From: [REDACTED]
Sent: 07 March 2026 16:28
To: Susan Haley
Subject: Re: BE/13/26/HH - 40 Greencourt Drive
Attachments: 40 Greencourt Dr 07-03-2026.pdf

I have been allocated application BE/13/26/HH - 40 Greencourt Drive and begun looking at the plans and noted that the scales do not correspond for the plans. Please could you amend the plans accordingly and email me the updated ones.

ADDRESS	40 Greencourt Dr, Bognor Regis PO21 5EU, UK
TITLE	FLOOR PLANS
PROJECT STATUS	PLANNING DRAWINGS
DATE	JAN 2026
REVISION	
SCALE	As Indicate @A1
SHEET No.	WD001
REFERENCE	0010/20/FA
DRAWN BY

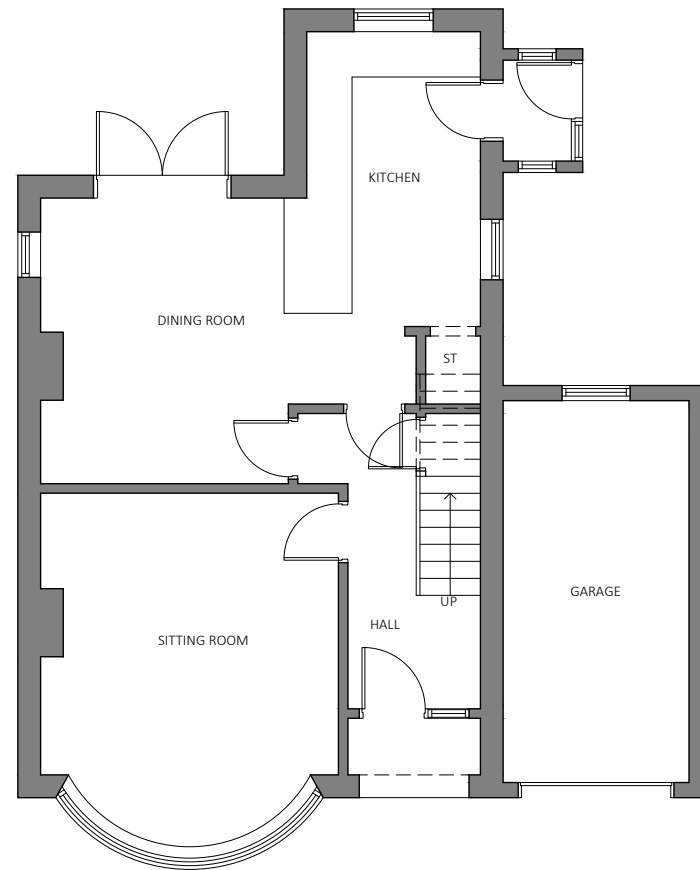
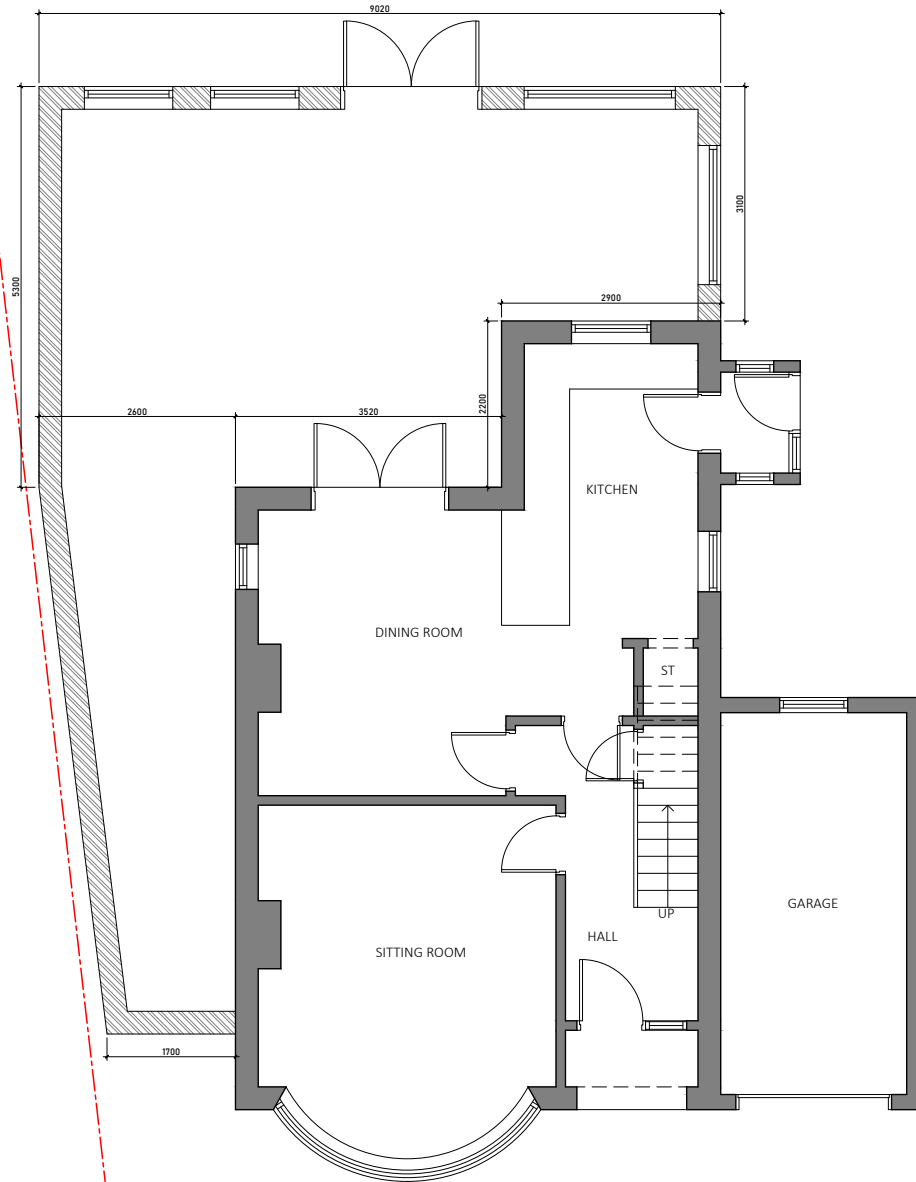
I have attached and example to show scale states 1:50 but measures 1:100

Thank you for your message. I have attached updated drawings with the correct scales hope thats all ok.
